Subject: Sand Creek Channel Design and Construction Documents Review (CDR-20-004)

The Park Operations Division of the Community Services Department has reviewed the Sand Creek Channel Design and Construction Documents and has the following additional comments of behalf of El Paso County Parks.

C204

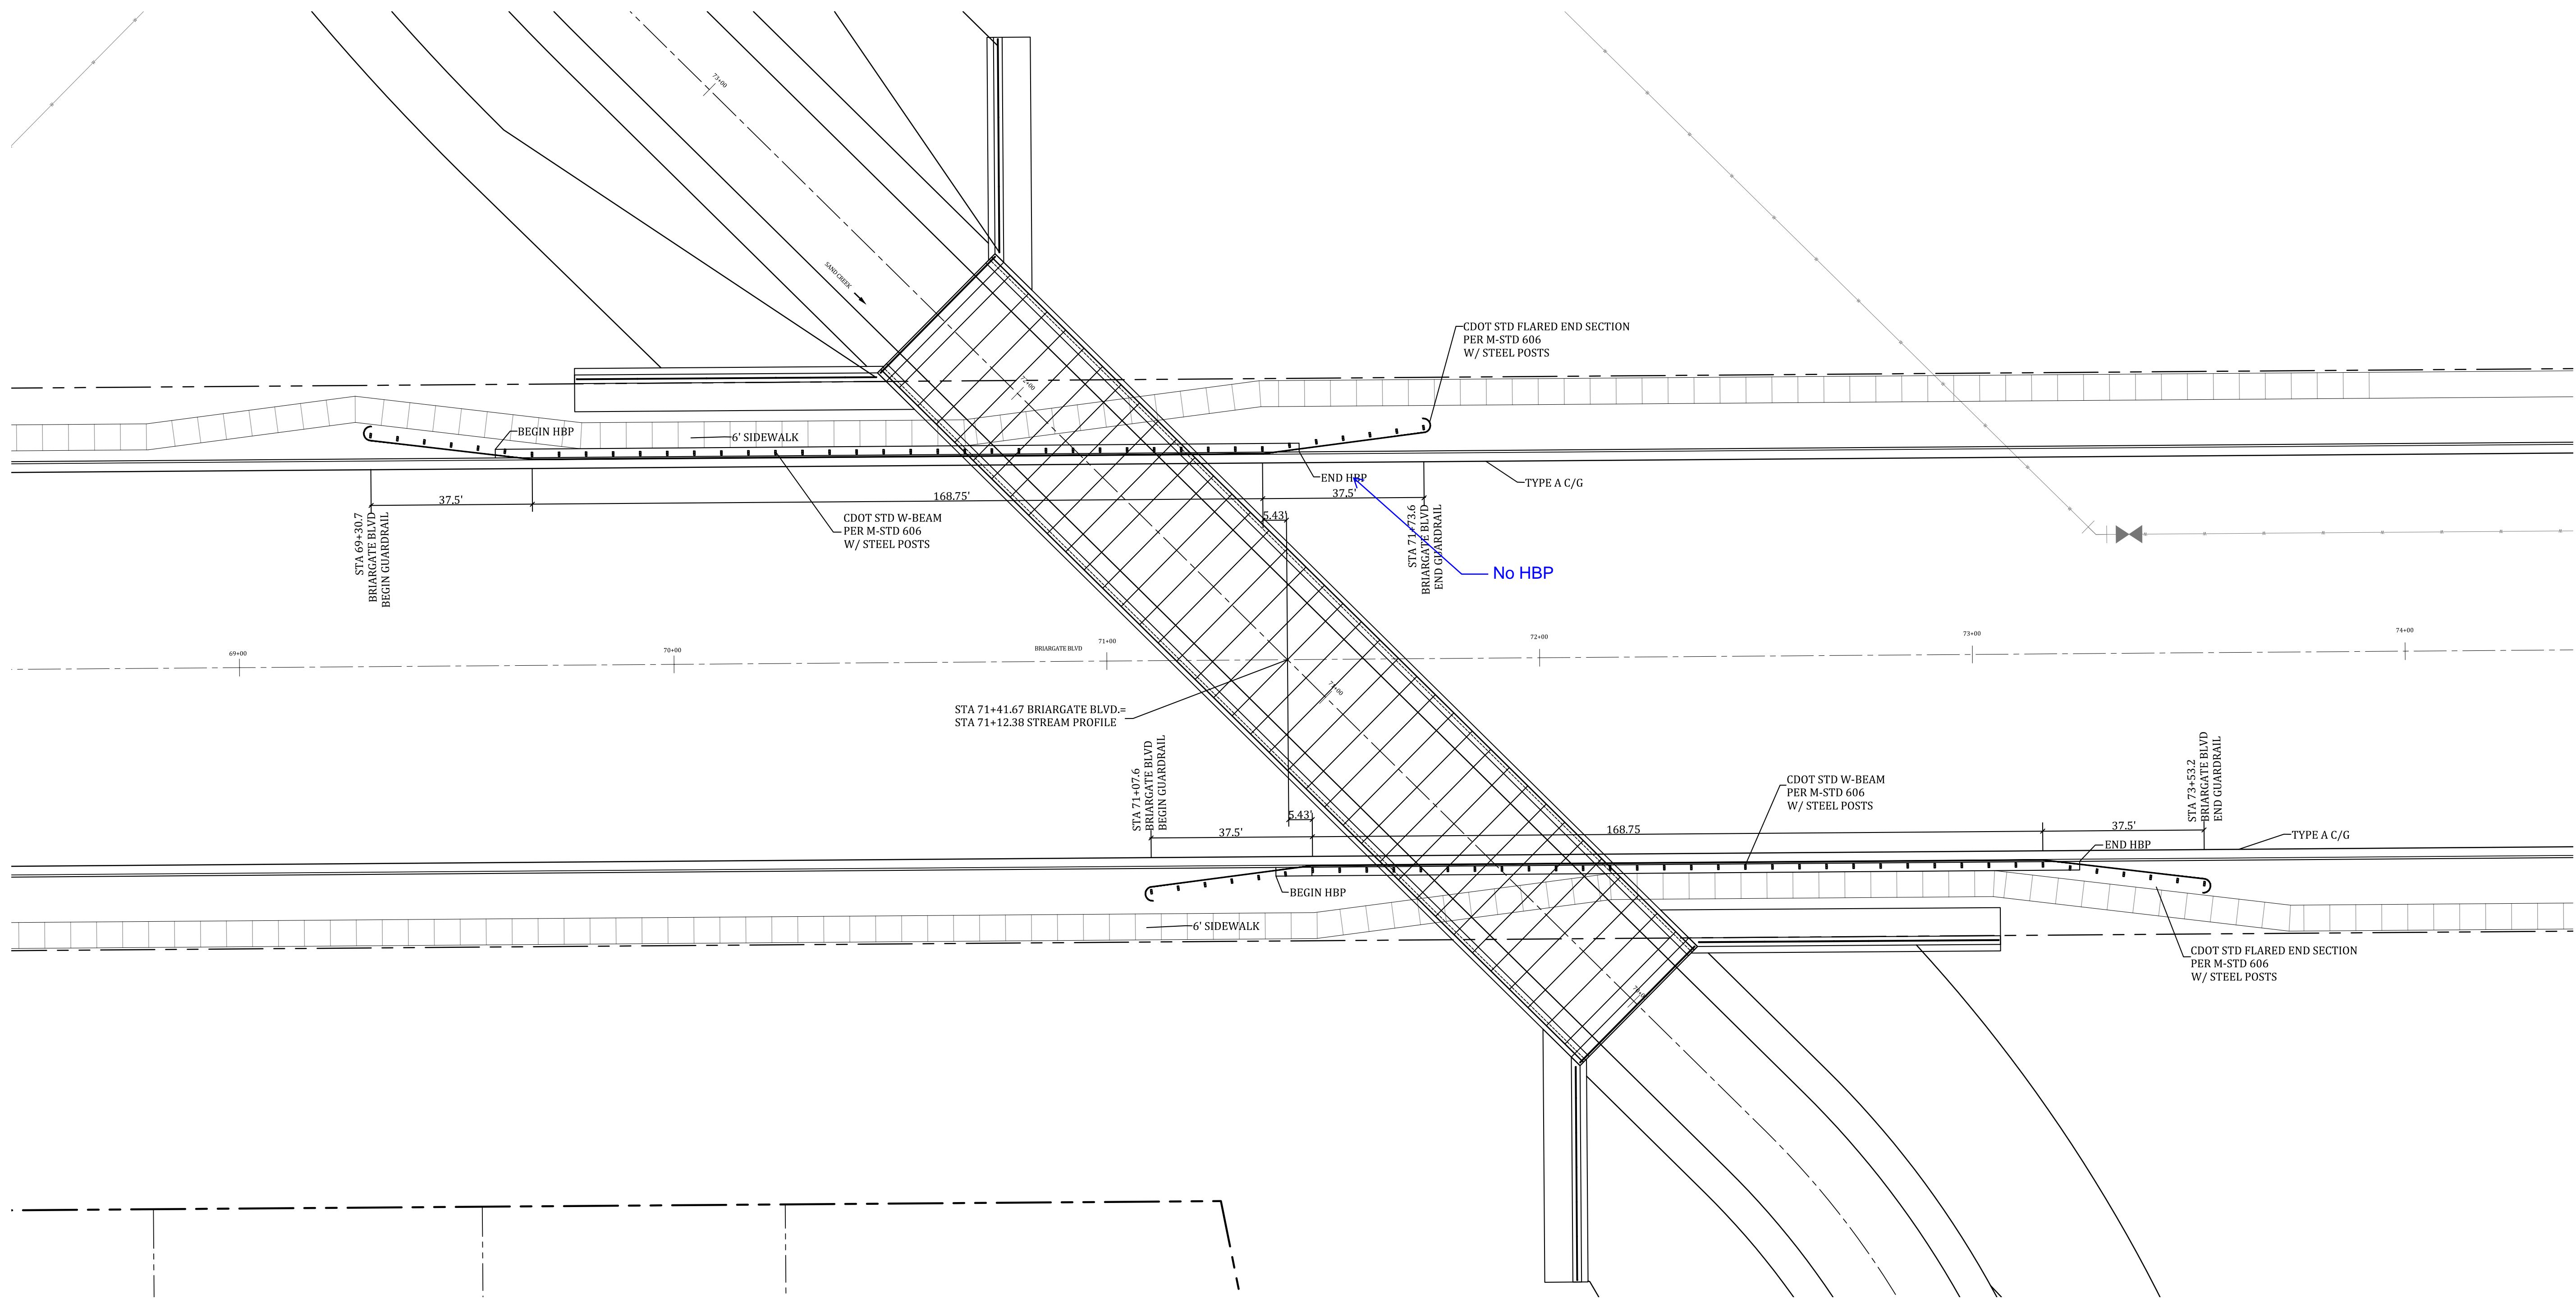
Pages C202 and C204 of the Construction Documents show the Briargate Boulevard Bridge design, including the locations of the proposed 6-foot wide sidewalk and guardrails, while a detail on C222 provides the general cross-section for the guardrail and sidewalk on either side of the bridge. Staff understands the constraints of routing the previously recommended 10’ concrete sidewalk and 5’ gravel trail across the bridge, between the wingwalls and guardrails for Briargate Boulevard, and further recognizes that certain aspects of the sidewalk and adjacent gravel trail may need to be modified and possibly narrowed within the bounds of the bridge structure. Staff recommends the applicant and designers show the approaches of the sidewalk and adjacent trail on the C202 or C204 layouts.
